**D. ALLEN HUGHES
ENGINEERING, Inc.**

February 20, 2025

Reference: Review of Foundation Plan for Proposed 23'-4" by 64' Scale House
Heidelberg Materials Gardner Quarry, 3155 NC 210, Bunnlevel, NC
Project No. D25ms42

SERIAL NUMBER: FSSI-10911AB	
REFERENCE # FSS-10911AB	STATES: NC
DATE: JANUARY 25, 2023	DESTINATION: BUNNLEVEL, NC
DRAFTSMAN: BRANDON R. DOYLE	SIZE: 23'-4" x 64' (DOUBLE-WIDE)
SCALE: NO SCALE	REVISIONS: N/A
CODES: 2018 NCBC (2015 IBC W/ NC AMENDS)	PLAN NO: FSS 10911AB (NC)
FOUNDATION	SHEET: 1 OF 1

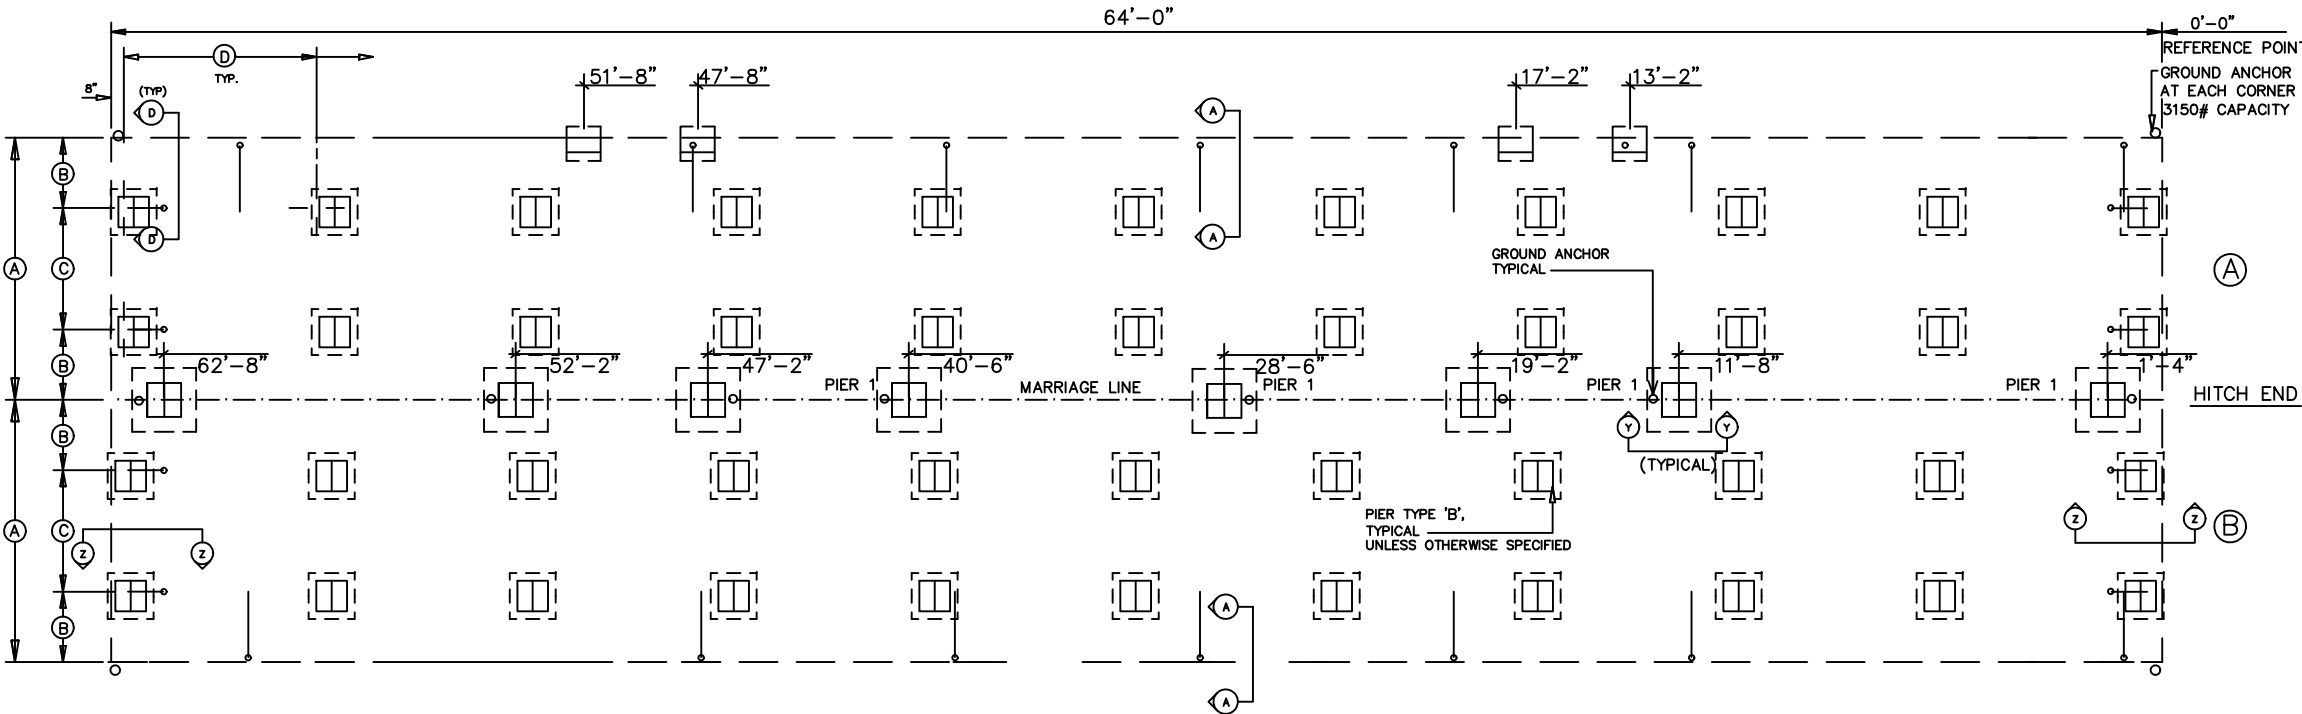
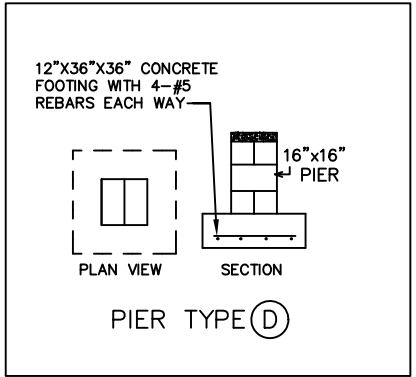
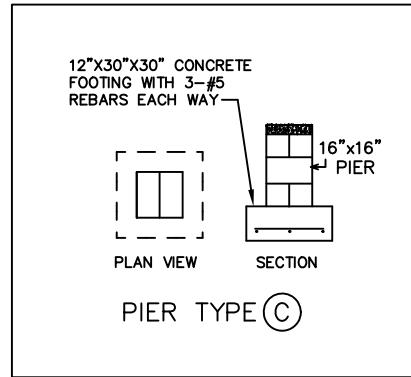
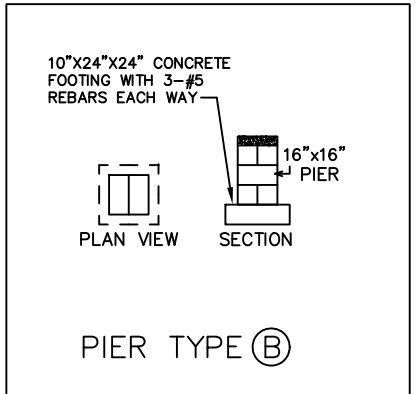
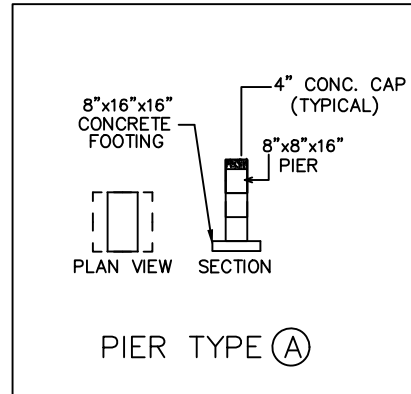
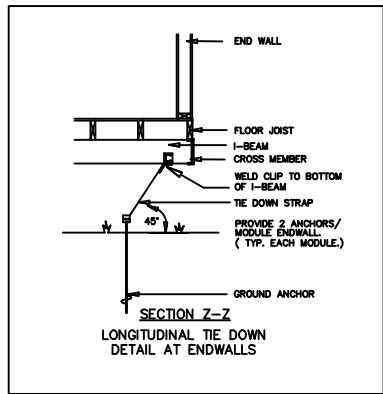
- The Foundation Plan by First String Space should be used unless recommended otherwise in the following recommendations.
- Our evaluation is based on an assumed bearing capacity of 2,500 psf to increase the factor of safety and reduce the chance of repairing areas relatively softer than the recommended 3,000 psf bearing.

- It is recommended that the marriage line piers be located as shown on the Foundation Plan by First String Space.
- It is recommended that the anchoring be installed according to the Foundation Plan by First String Space.

- The chassis beam pier footings may be 20"x20"x8" concrete footings and the marriage footings should be at least 30"x30"x10" concrete footings. As long as the footing thickness is greater than the footing projection, no steel reinforcing is required.

- The chassis beam piers and footings should be spaced at 9 ft. along the chassis beams with the end piers being within 2 ft. of each end of each chassis beam.

- The marriage line piers should be 16"x16" masonry piers.
- The chassis beam piers may be 8"x16" masonry piers up to heights of 36 in. Higher than 36 in. should be 16"x16" masonry piers.

- As an alternate to using mortar at the joints in the masonry piers, they may be coated from the footing with a 1/8 in. layer of surface bonding cement mixed and applied according to the manufacturer's specifications.
- Any issues not addressed in this report should be constructed in accordance with the Foundation Plan, NC Building Code, 2018 and the Geotechnologies report.
- The local inspections department or D. Allen Hughes Engineering should observe the completed foundation and anchoring system once the recommendations have been implemented.
